10 Island Street

I am writing to oppose the proposed development of a house on the waterfront lot at 10 Island Street.

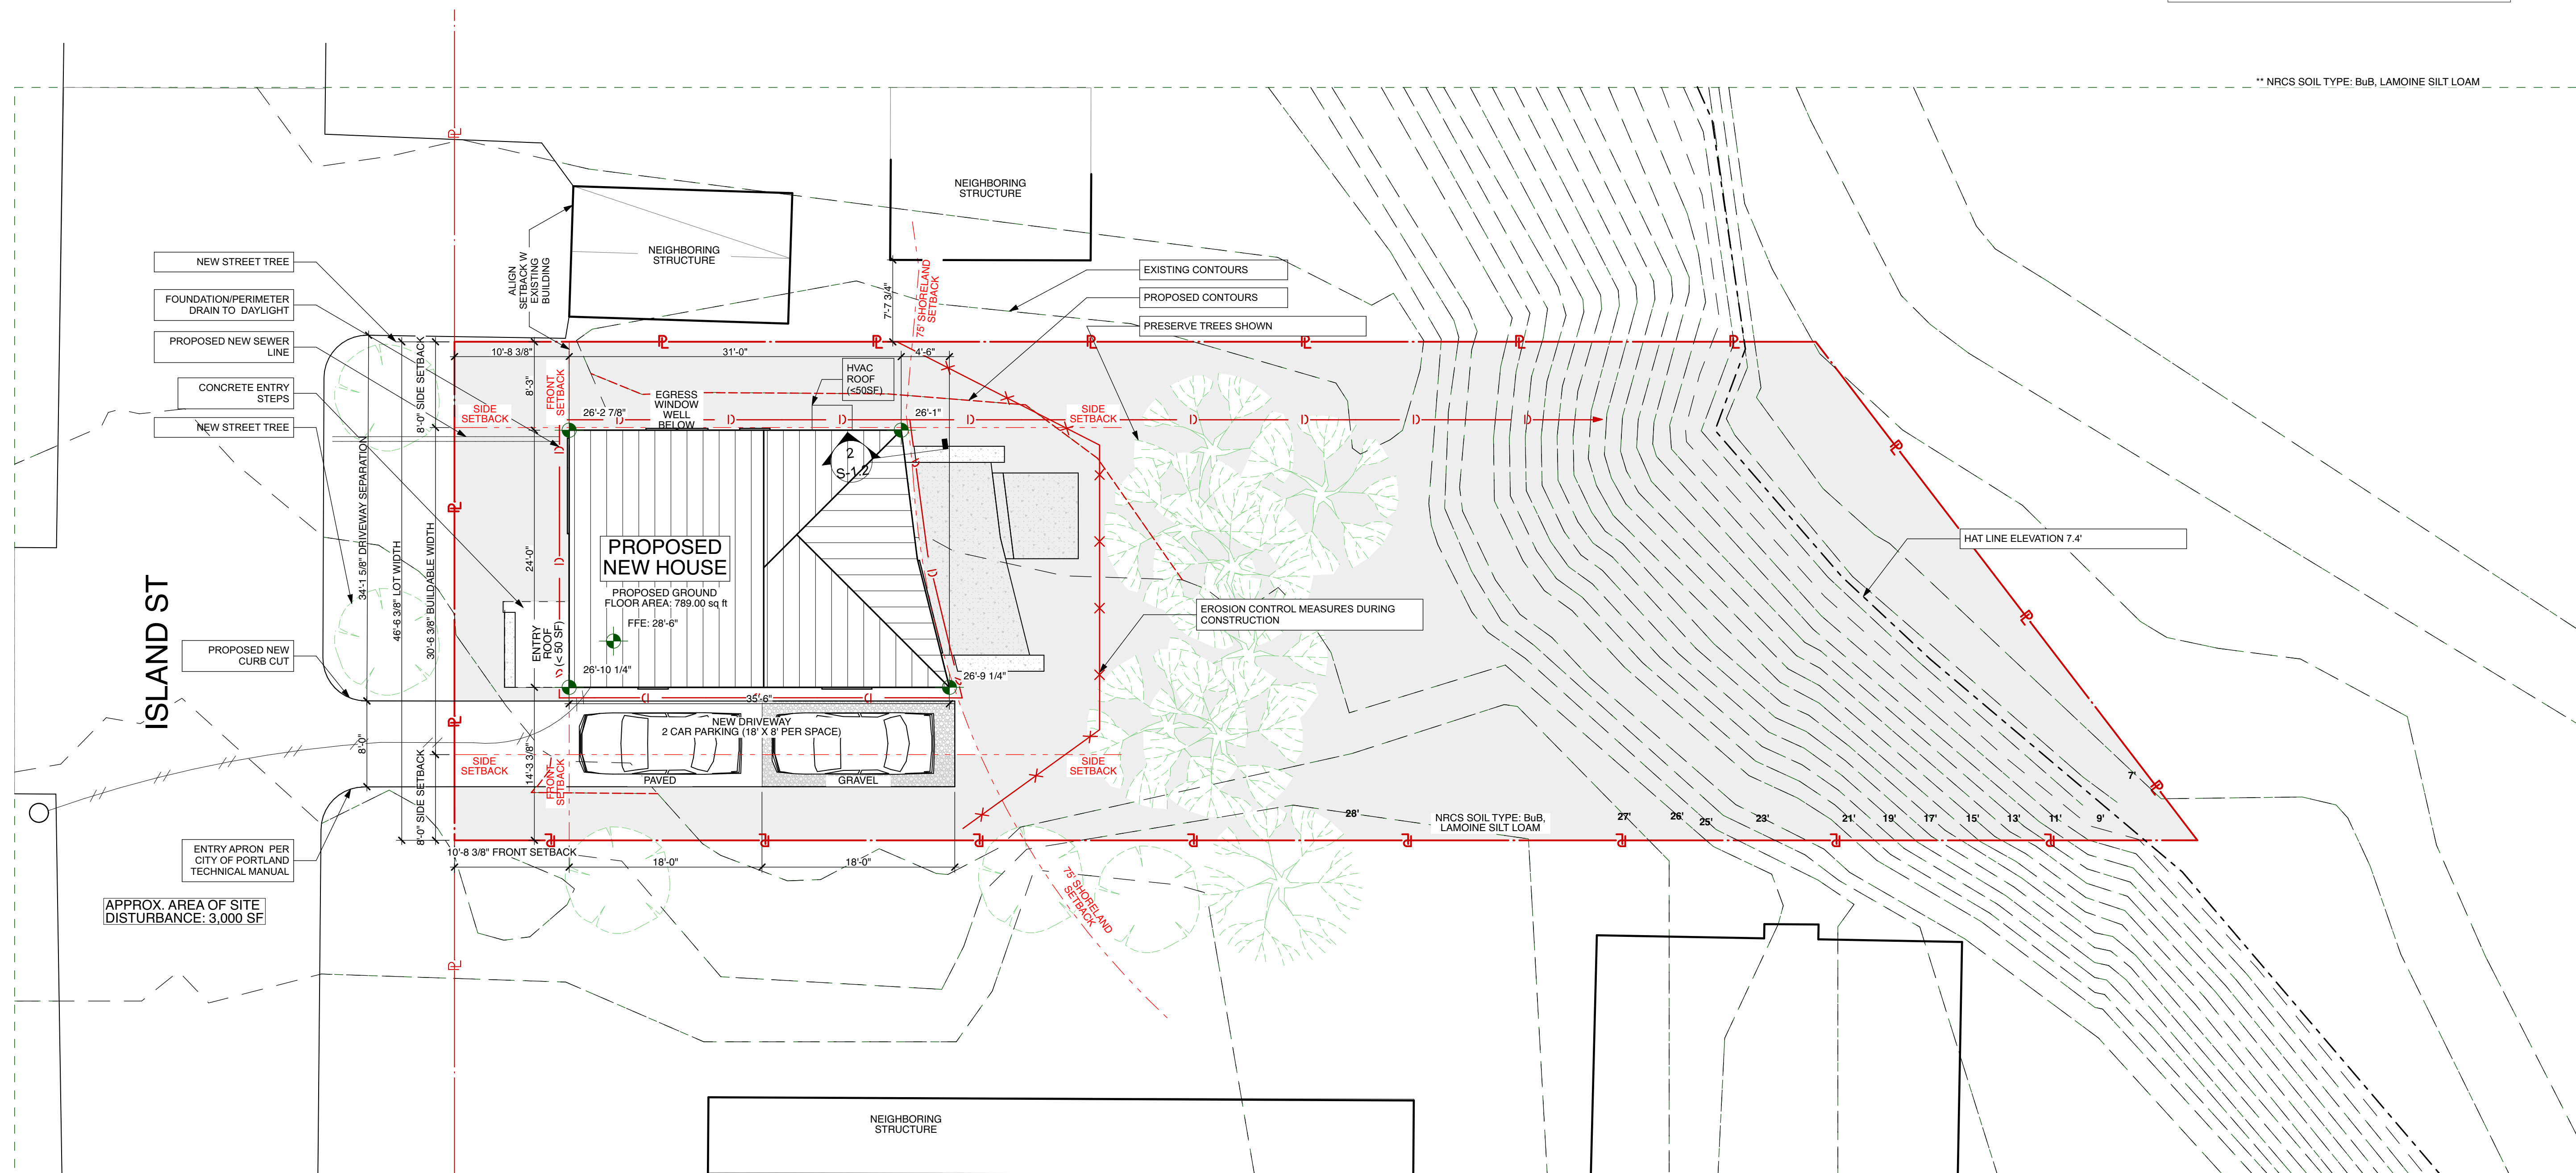
1. The site plan does not accurately depict the 75 foot shore land zone setback. You need to remeasure using the 2017 HAT line. Water is rising steadily throughout the City. Until you remeasure the application is incomplete and should not be acted upon.
2. A deck should not be permitted within the 75 foot setback.
3. The applicants are not adhering to the full set back from the front of the street. They are using roughly the same setback based on abutting properties. It is important that you compare the front setback plan to nearby properties and see whether the front setbacks are greater than the abutting properties.
4. The side setbacks are too generous. They should not both be eight feet. One side should be 14 feet.
